April 16, 2003

**Re: Keith Apartments Grading and Drainage Plan (K-11/D67)
Engineer's Stamp Dated March 7, 2003**

**Re: Keith Apartments Grading and Drainage Plan (K-11/D67)
Engineer's Stamp Dated February 4, 2003**

The above referenced grading and drainage plan received February 4, 2003 is approved for Site Development Plan for Building Permit. Prior to Building Permit and SO19 Permit approvals the following comments must be addressed:

GRADING AND DRAINAGE PLAN

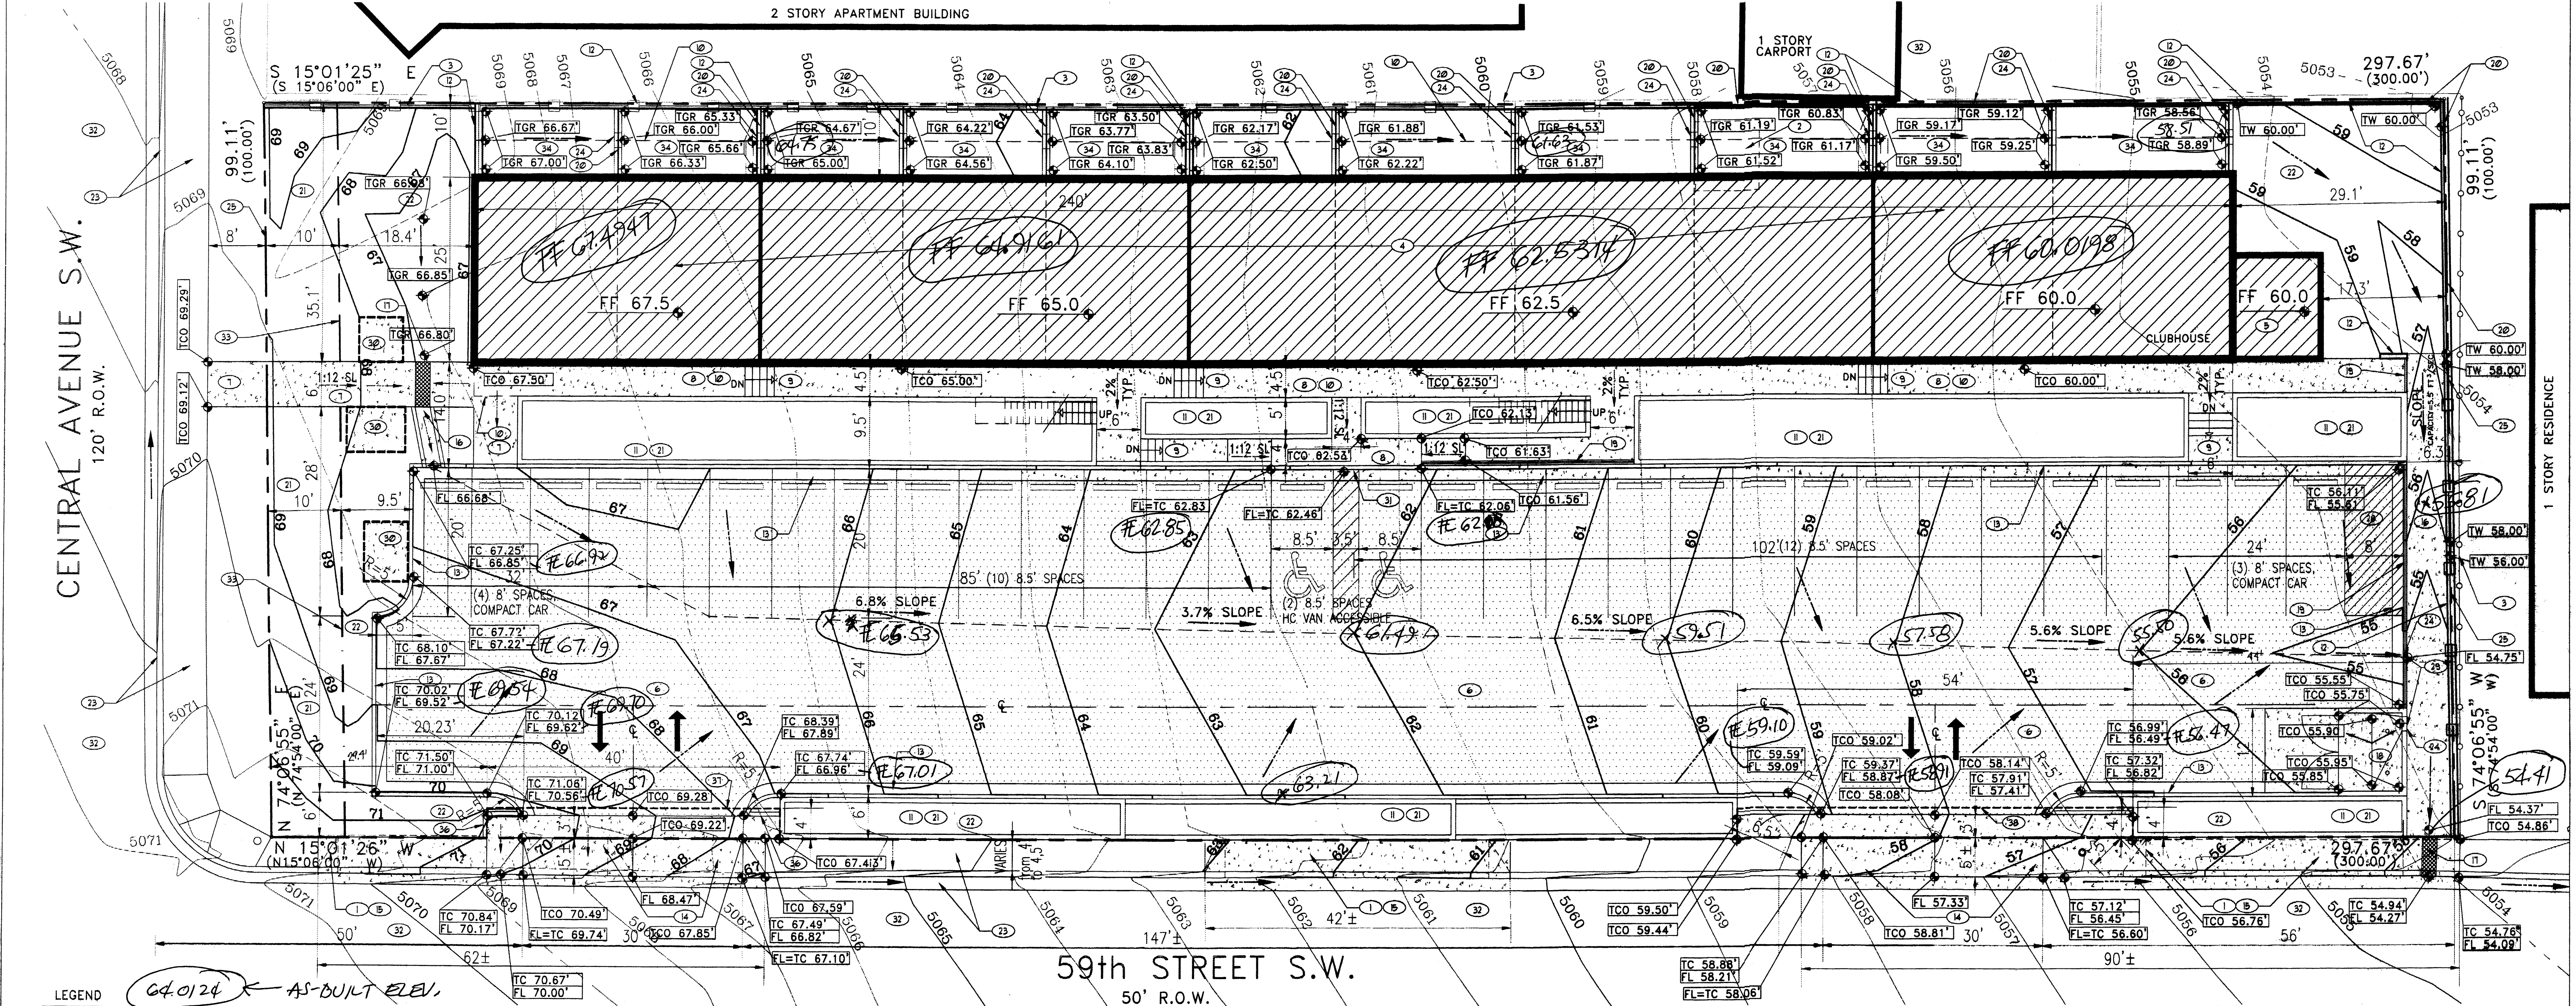
- Please provide capacity and dimensions of channel along south end of lot.
- Please provide capacity and width of sidewalk culvert.
- Please provide a duplicate plan for City Storm Drain Maintenance Inspector with next submittal.
